Cottam Solar Project

Land Plan Revision C – Change Application

Prepared by: Dalcour Maclaren
December 2023

PINS reference: EN010133
Document reference: CR1/C2.2_C_CR
APFP Regulation 5(2)(i)

Land Plans
Sheet 14 of 19
Revision B

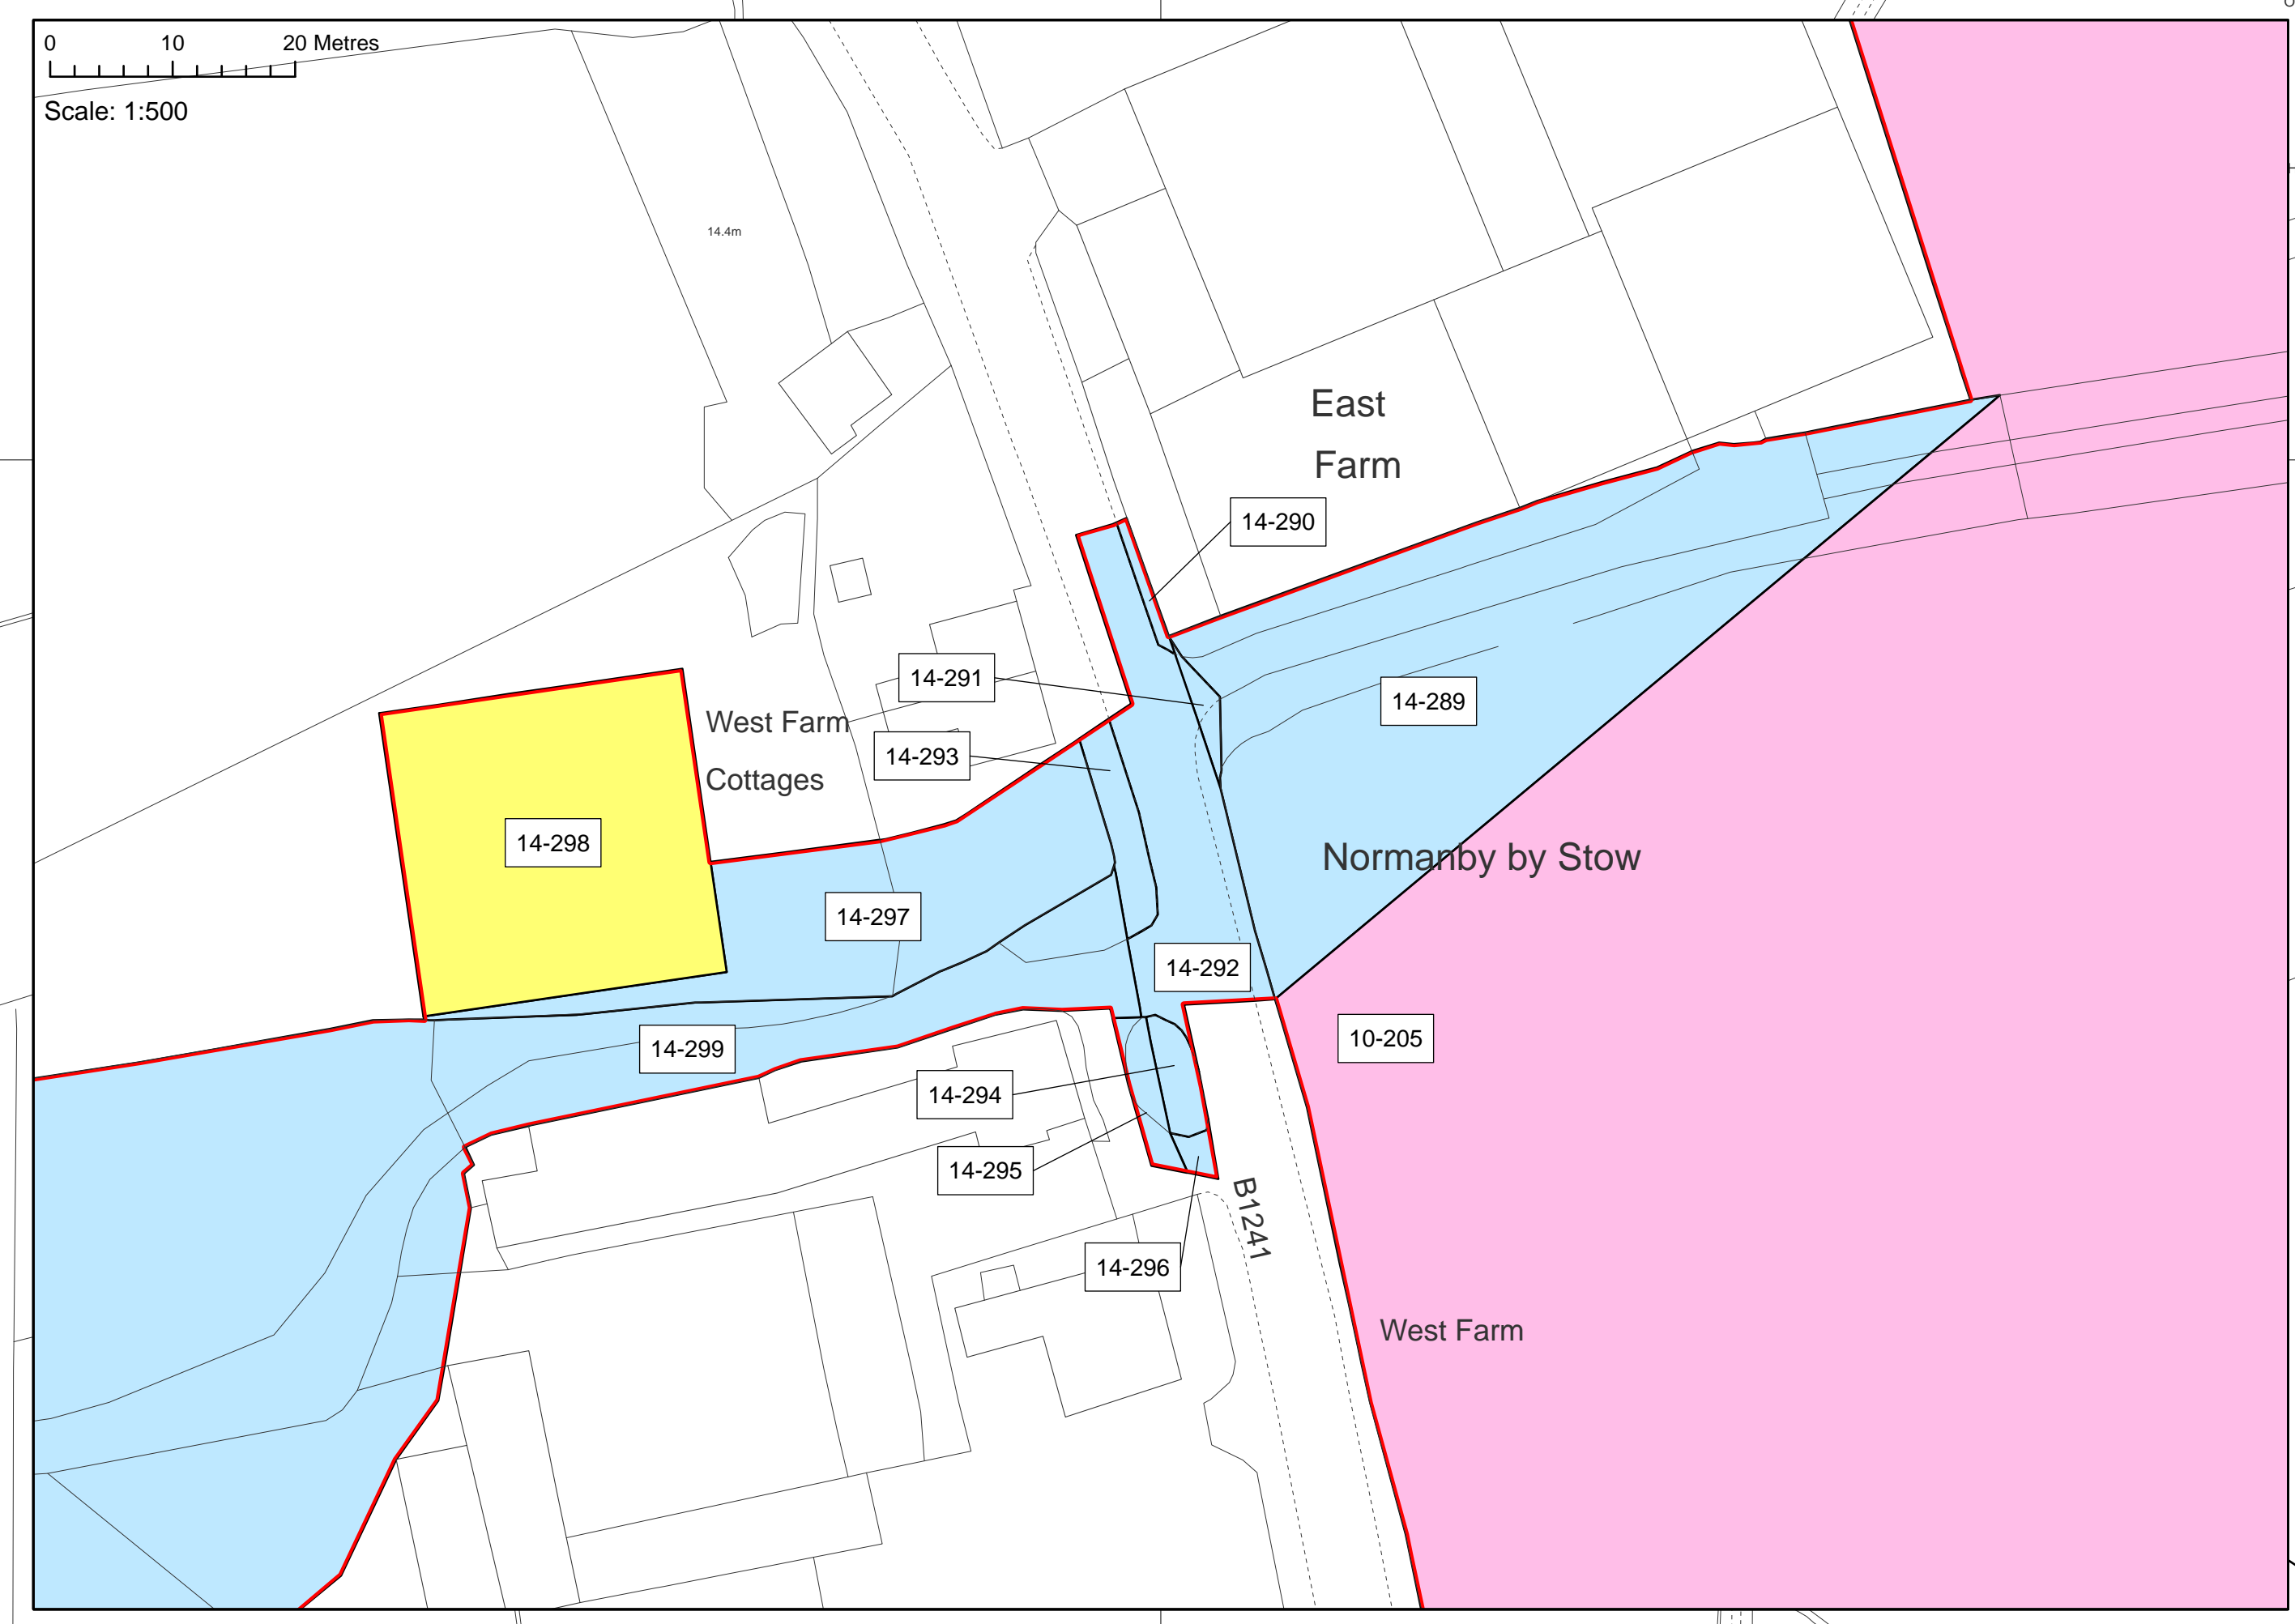
Sheet 14 of 20	18	Plots removed	Plots 14-297, 14-298, 14-299 and 14-300 are no longer required for the DCO application
Sheet 14 of 20	18	New plots added	Changes in the Red Line Boundary have created plots 14-284a, 14-284b, 14-284c, 14-284d, 14-284e, 14-284f, 14-284g, 14-292a, 14-292b, 14-293a

Sheet 14 of 20	18	Change in acquisition	Plots 14-290, 14-292, 14-293, 14-294, 14-295, 14-296 have changed from blue symbology (New Rights) to yellow symbology (Temporary use of land)

Sheet 14 of 20	18	Change in acquisition	The extent of plots 14-290, 14-292, 14-293, 14-295 and 14-301 have changed to align with the updated Red Line Boundary

Sheet 14 of 20	18	Update to the list of plots in the key on Sheet 14	Updated to reflect addition of new plots 14-284a, 14-284b, 14-284c, 14-284d, 14-284e, 14-284f, 14-284g, 14-292a, 14-292b, 14-293a

Sheet 14 of 20	18	Update to the list of plots in the key on Sheet 14	Updated to reflect removal of plots 14-297, 14-298, 14-299 and 14-300
Sheet 15 of 20	19	Plots removed	Plots 14-297, 14-298, 14-299 and 14-300 are no longer required for the DCO application
